Ref: Engineering Inspection
Jose Santiago Residence
136 Curtis Dr
Erwin, NC 28339
Chuck Smith Contractor

I made an onsite visit to the residential building site referenced above on March 14, 2023. The purpose of the visit was to examine Two Items that were on an Inspector's punch List. Below are my findings .

Additional Drawing Showing Kitchen
BRES - 2203-0044

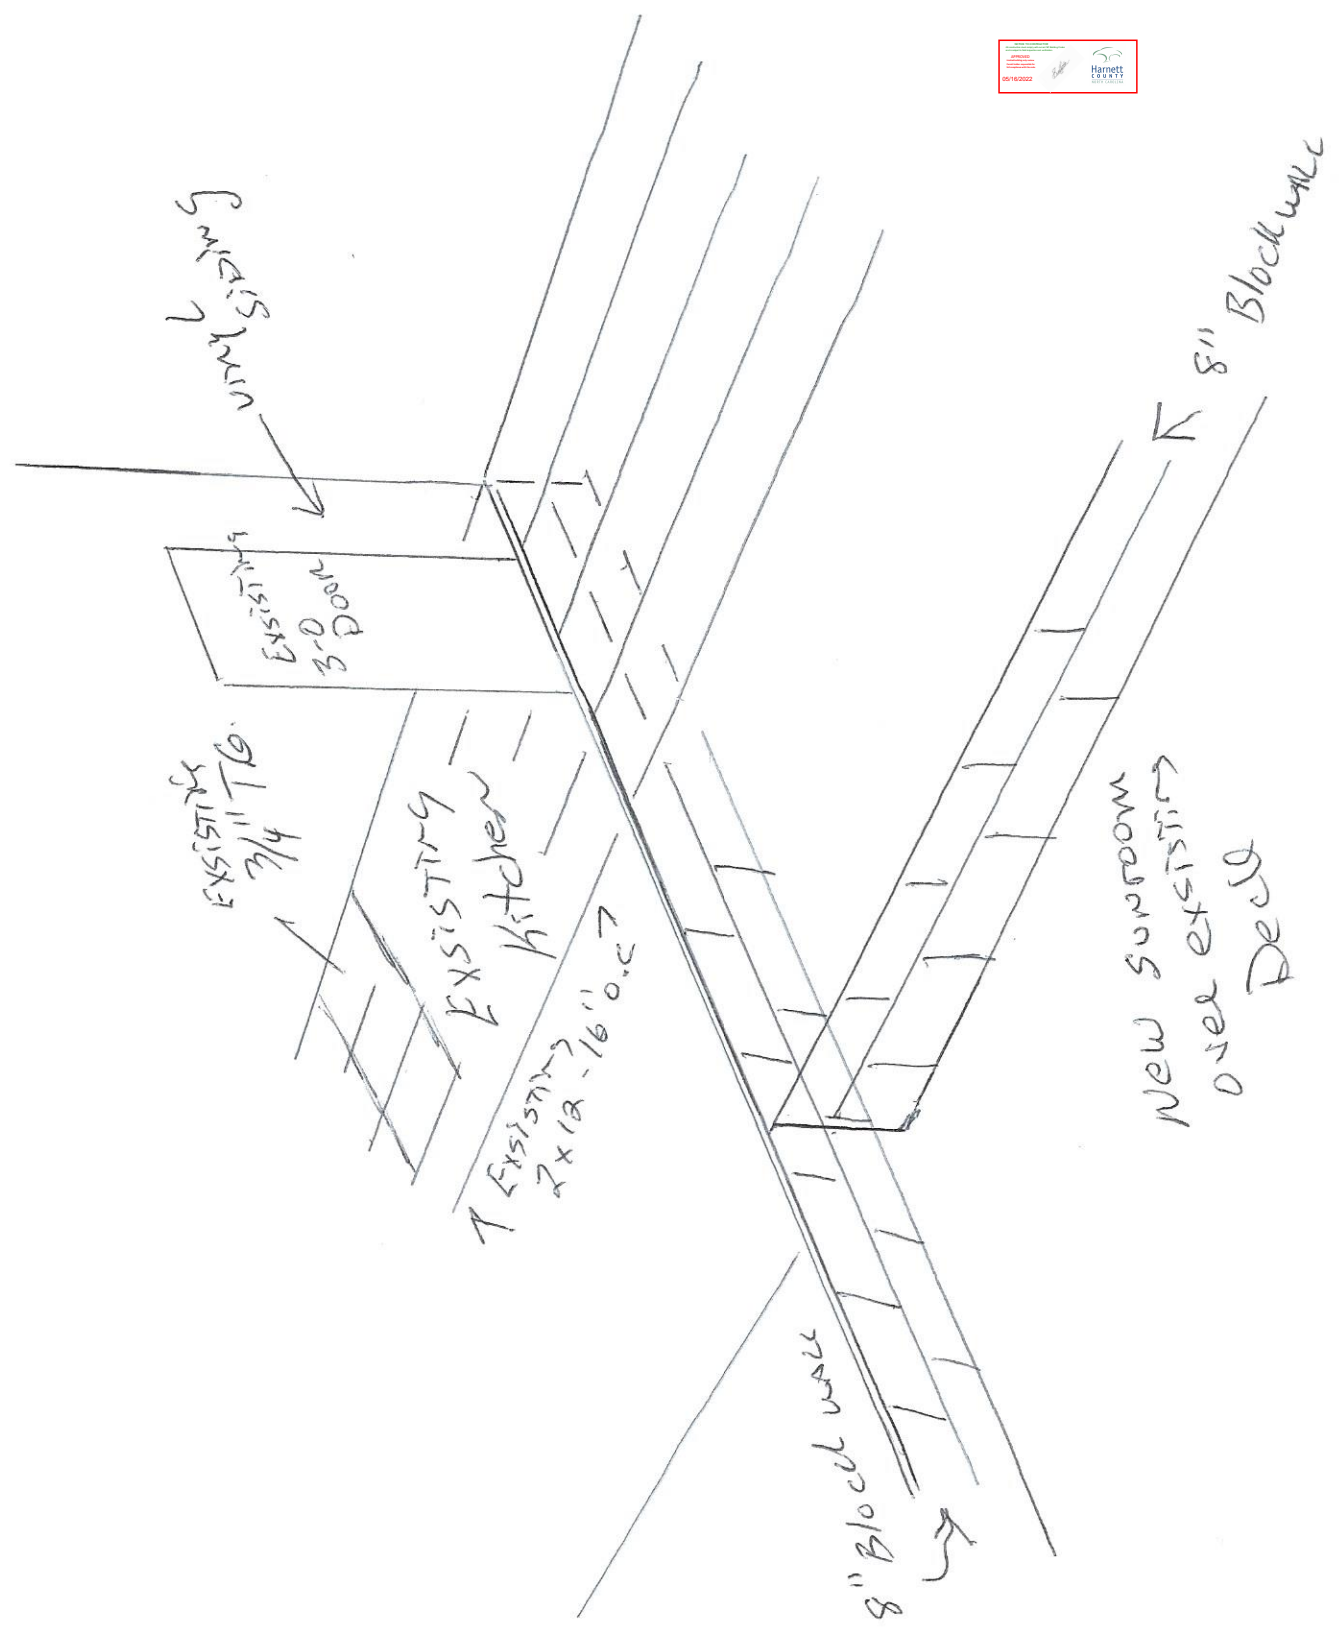
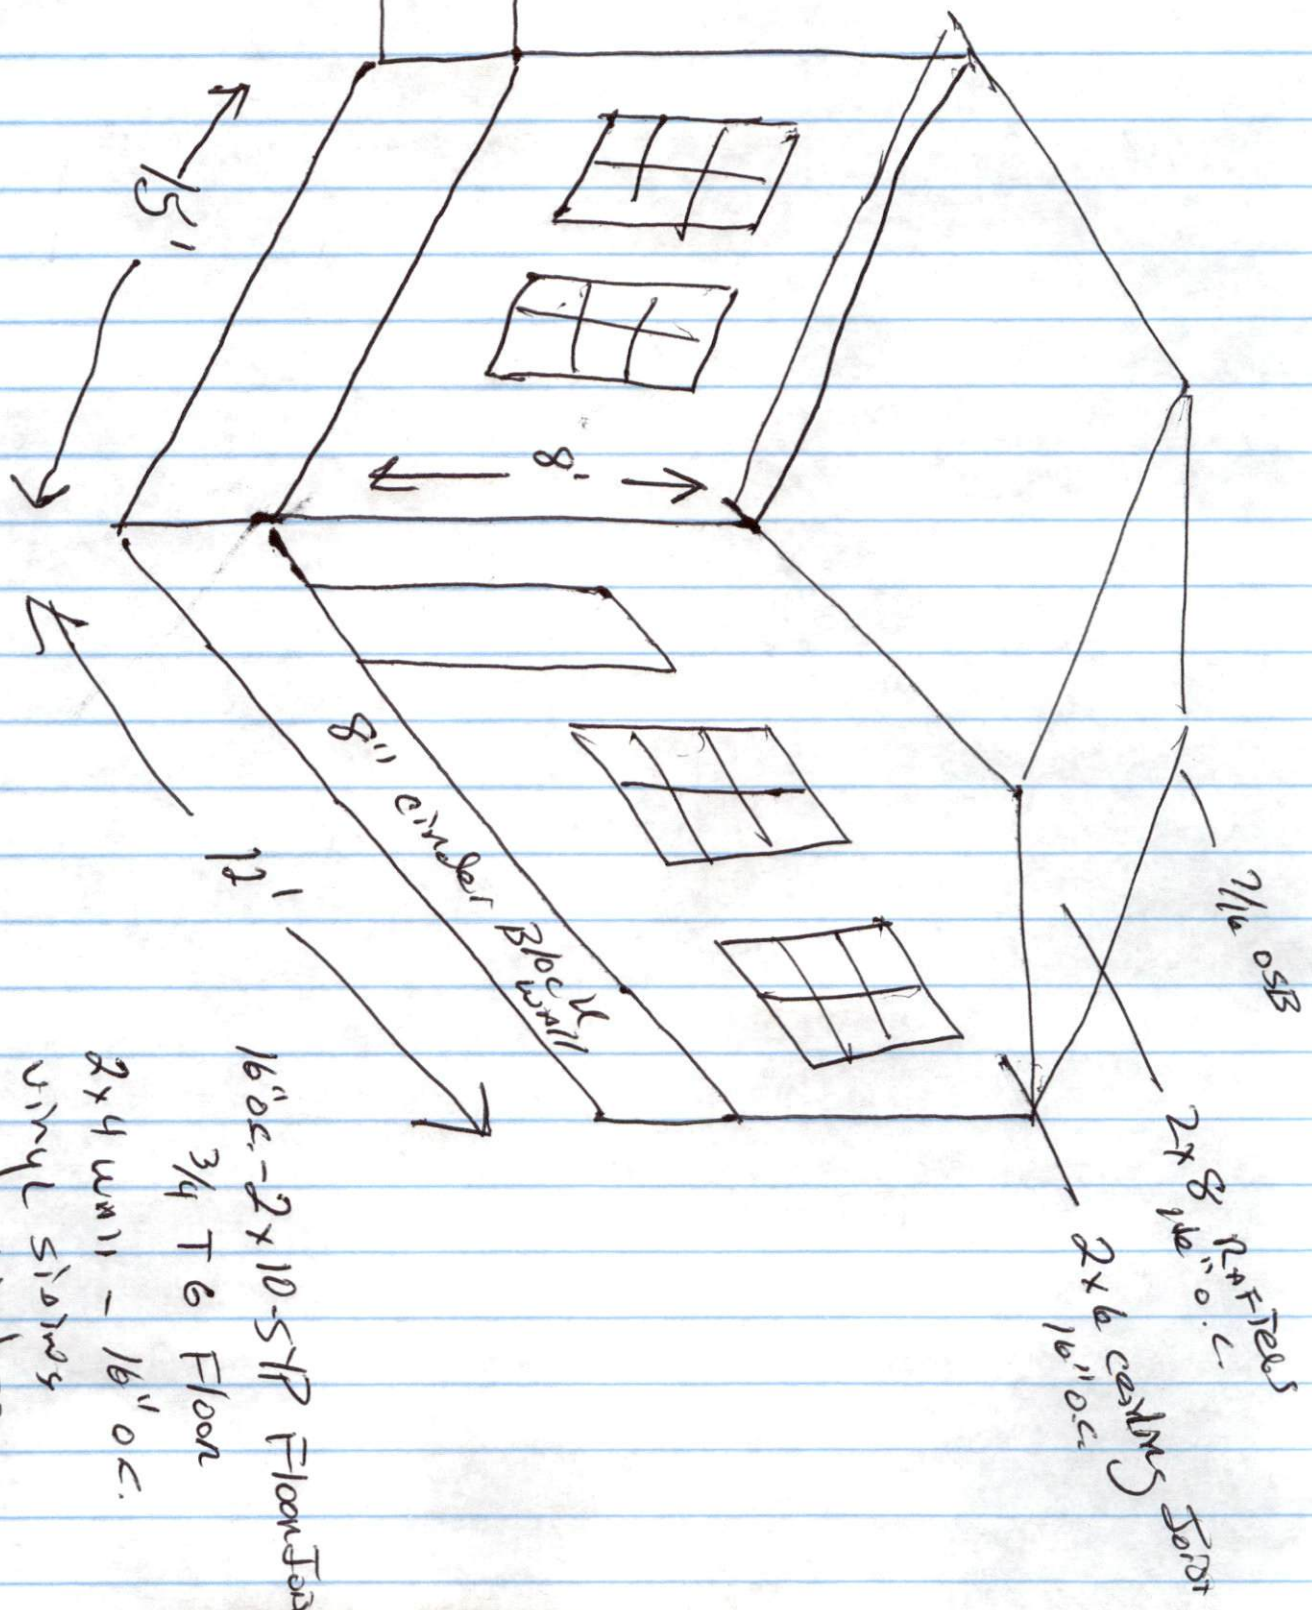
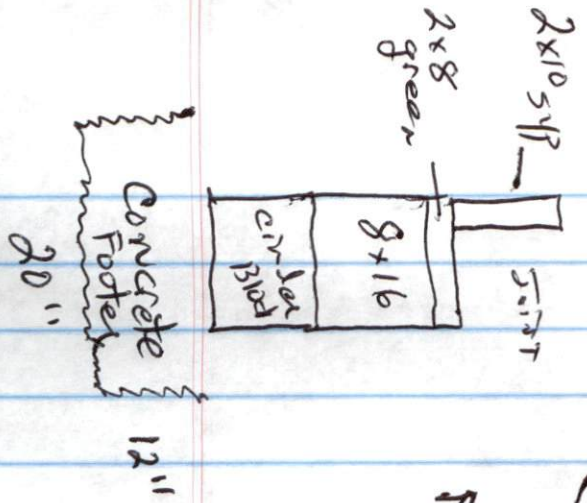
Item #1- The Footing at new sun porch. I had the contractor remove soil at several locations around the 12 x 15 foot porch foundation, The depth, width & projection meets code

Item #2- The lack of bolts at ledger. I also approve the placement of the two 5/8" dia thru bolts at the ledger board.

The items listed above will support the live and dead loads as specified in the North Carolina State Residential Building Code. 2018,ed.
